## **YORKSHIRE AND HUMBER CCS PIPELINE**

### **THE EXAMINING AUTHORITY'S (EXA'S) FIRST WRITTEN QUESTIONS AND REQUESTS**

#### **RESPONSE FROM SELBY DISTRICT COUNCIL (SDC)**

TITLE
**CAMBLESFORTH MULTI-JUNCTION
ELEVATIONS (S + W)**

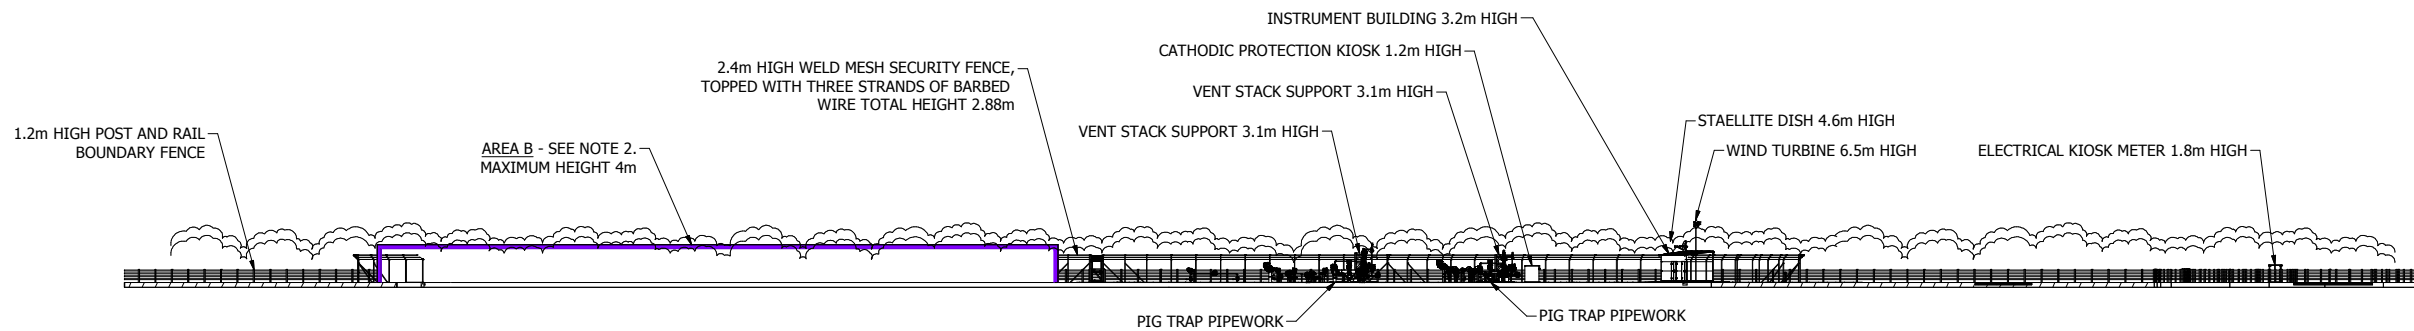
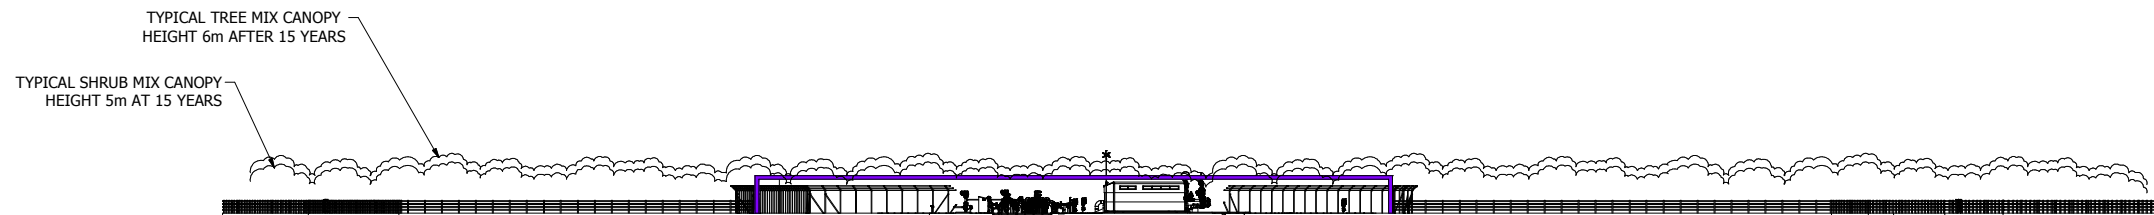
**Q1.13 – It is noted that Area B of the Camblesforth multi-junction (an outline area providing capacity for a further three PIG Traps that would be needed to accommodate future connections to the pipeline but will be grassed in the meantime (para 4.2.1 of ES Chapter 3)) and Barmston pumping station are being applied for at outline level. Parameter plans have been produced for each of these project components which include the maximum dimensions of buildings. Can the applicant and local planning authorities consider whether the DCO is sufficiently detailed for these components and how would these “reserved matters” be controlled?**

Selby District Council are satisfied that Requirements 6 (1) to 6 (3) of Schedule 3 of the Draft DCO provide sufficient control for the details to be submitted prior to the commencement of works in Area B of the Camblesforth Multi Junction and that the parameters plan 10-2574-GA-01-0316 for Area B is of sufficient detail to enable proper consideration of the likely environmental effects in accordance with the ‘Rochdale Envelope Principle’. Selby District Council can also confirm that the applicant discussed the use of Reserved Matters and Rochdale Envelope Principle at an early stage.
